## EL PASO COUNTY GRADING AND EROSION CONTROL PLAN CHECKLIST

PPR2342

INITIAL GRADING & EROSION CONTROL PLAN
 PROJECT NO. 21814-00CSCV
 DRAWING NO.

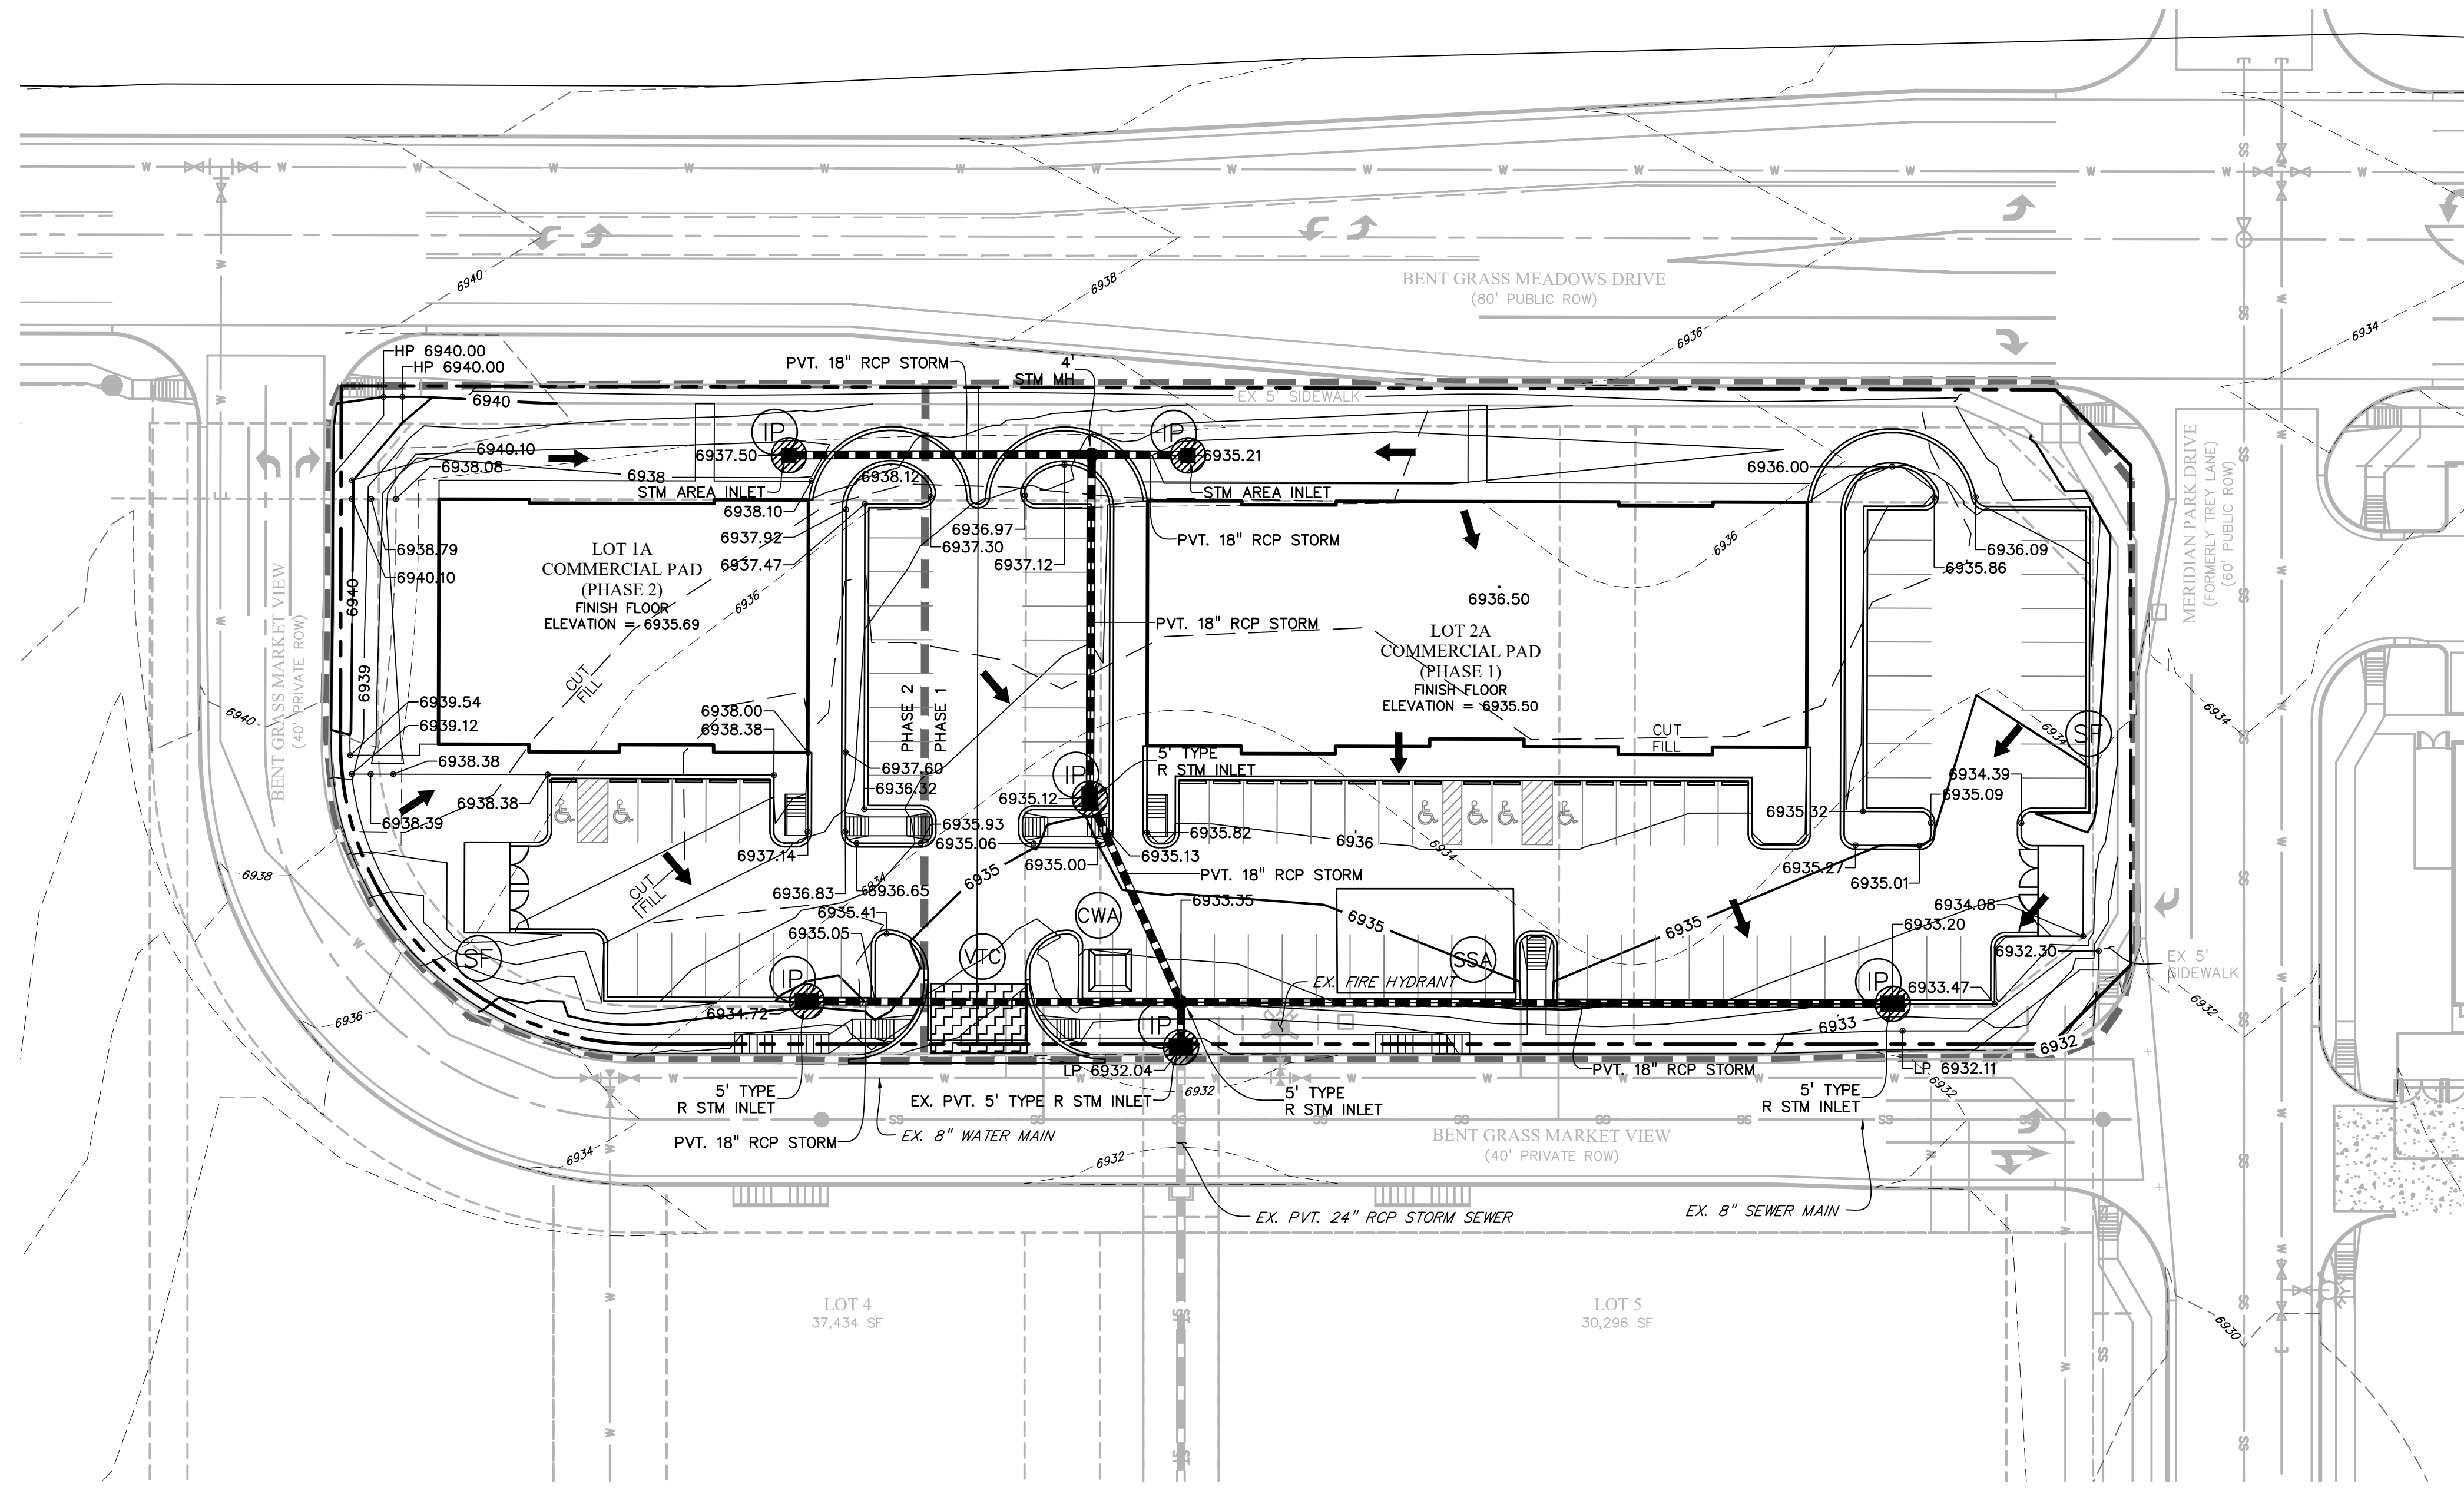
See my comment on Sht 2 of the GEC Plan
